DRB Application No.: 09DRB-70350 Project # 1008064
 Project Name: LANDS OF RAYMOND C. WATSON
 Agent: WAYTONE SURVEYING Phone No.:

DRB Comments

RE: Lot 1, Lands of Raymond C. Watson

RE: Minor Preliminary/Final Plat of Tracts 1-A, 1-B and 1-C, Lands of Raymond C. Watson,
Project No. 1008064

PLAT OF
TRACTS 1-A AND 1-B,
LANDS OF RAYMOND C. WATSON

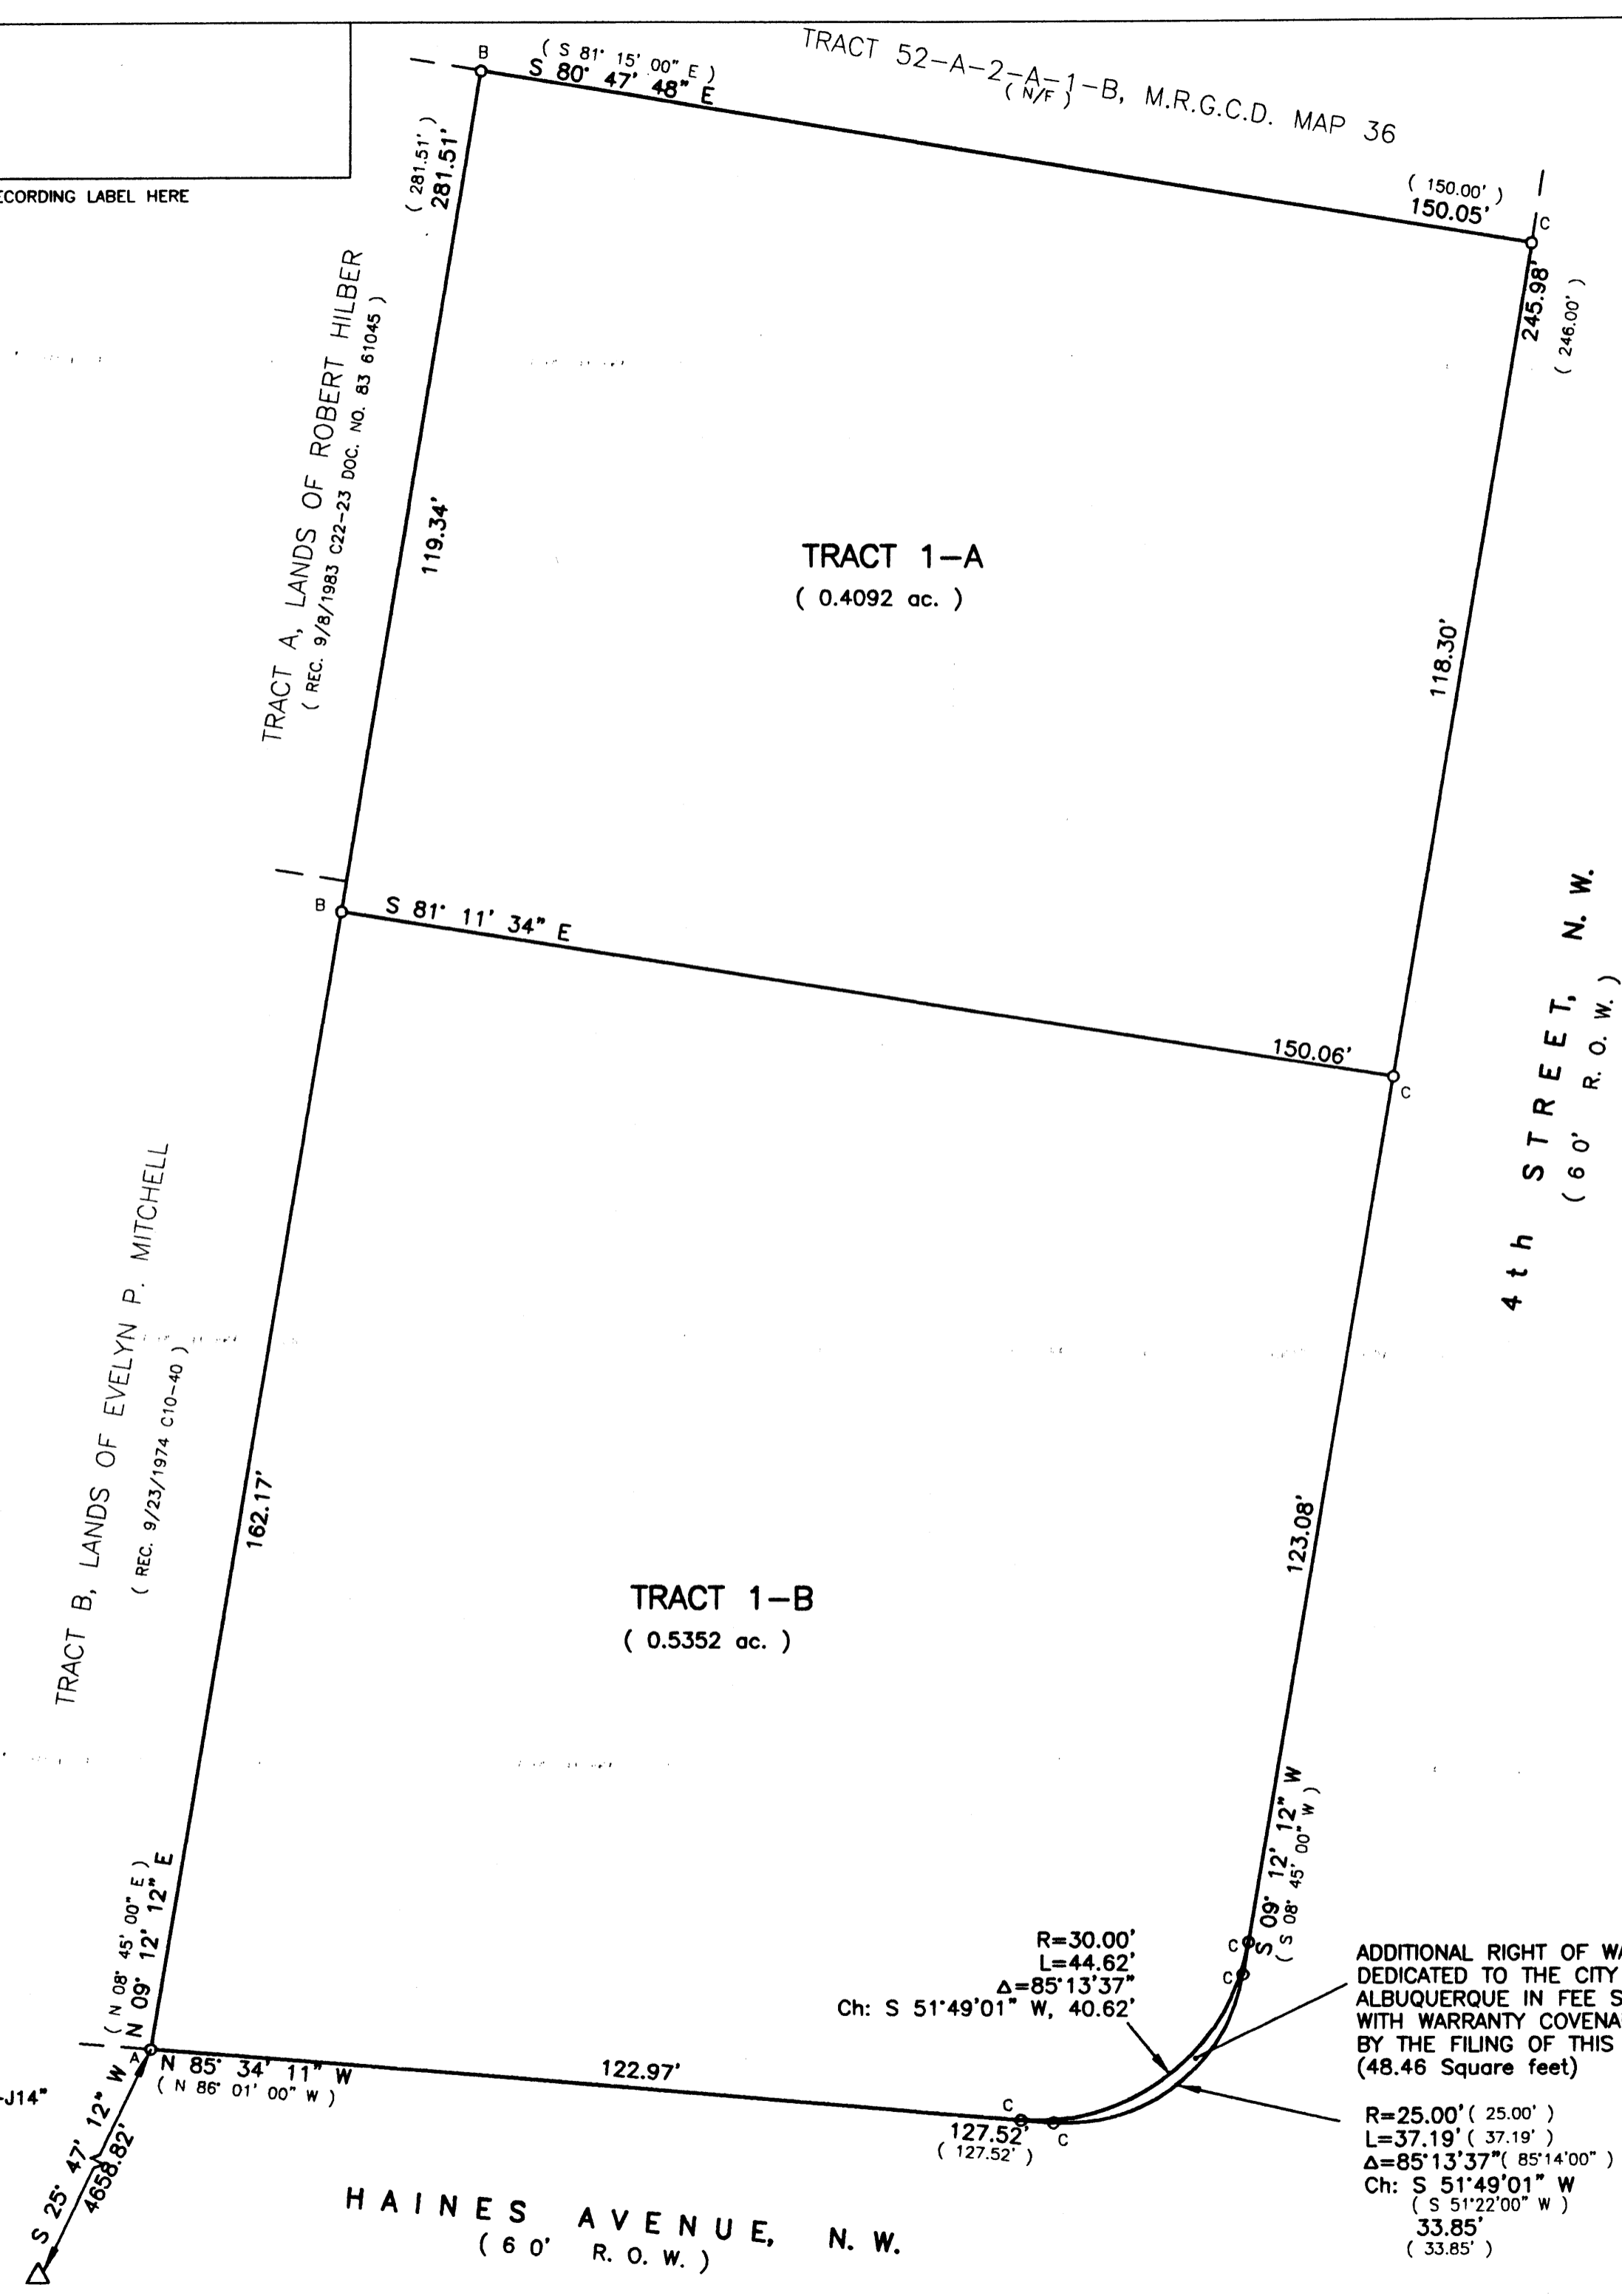
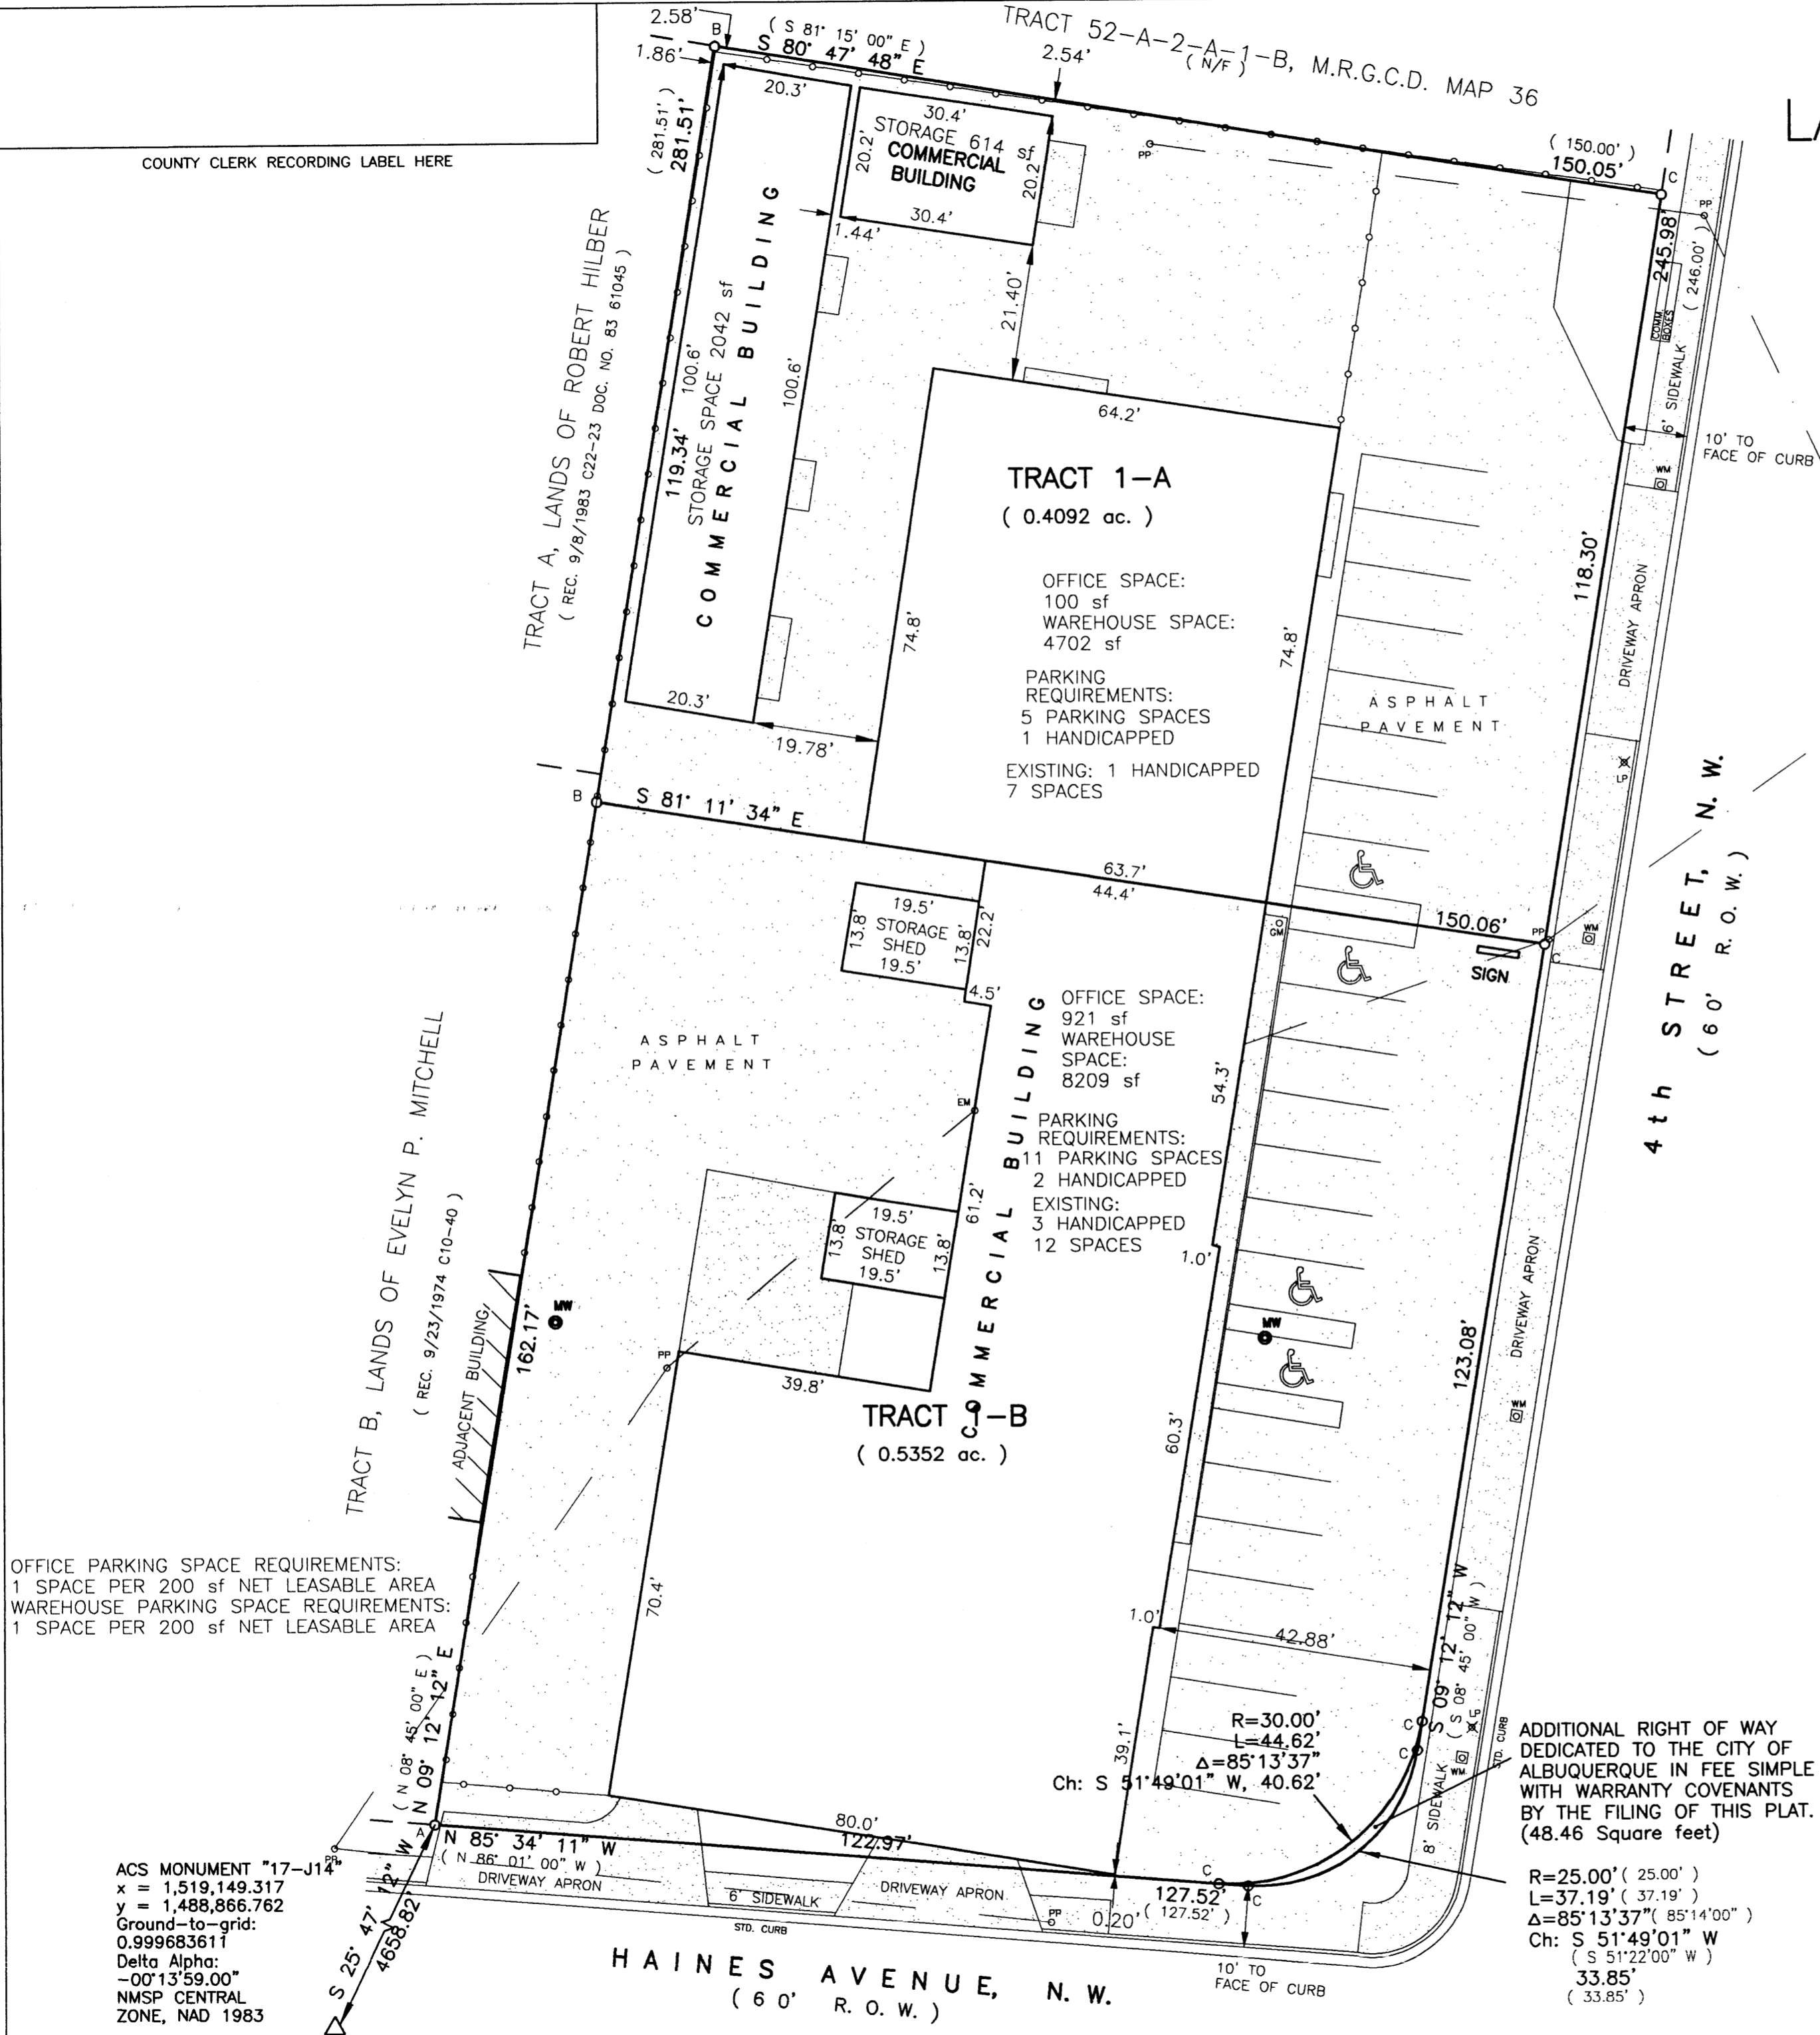
Reciprocal Access and Drainage Easements are needed, with Maintenance and Beneficiaries noted on the plat.

Certification is needed that the building complies with the building code in relation to the proposed lot lines.
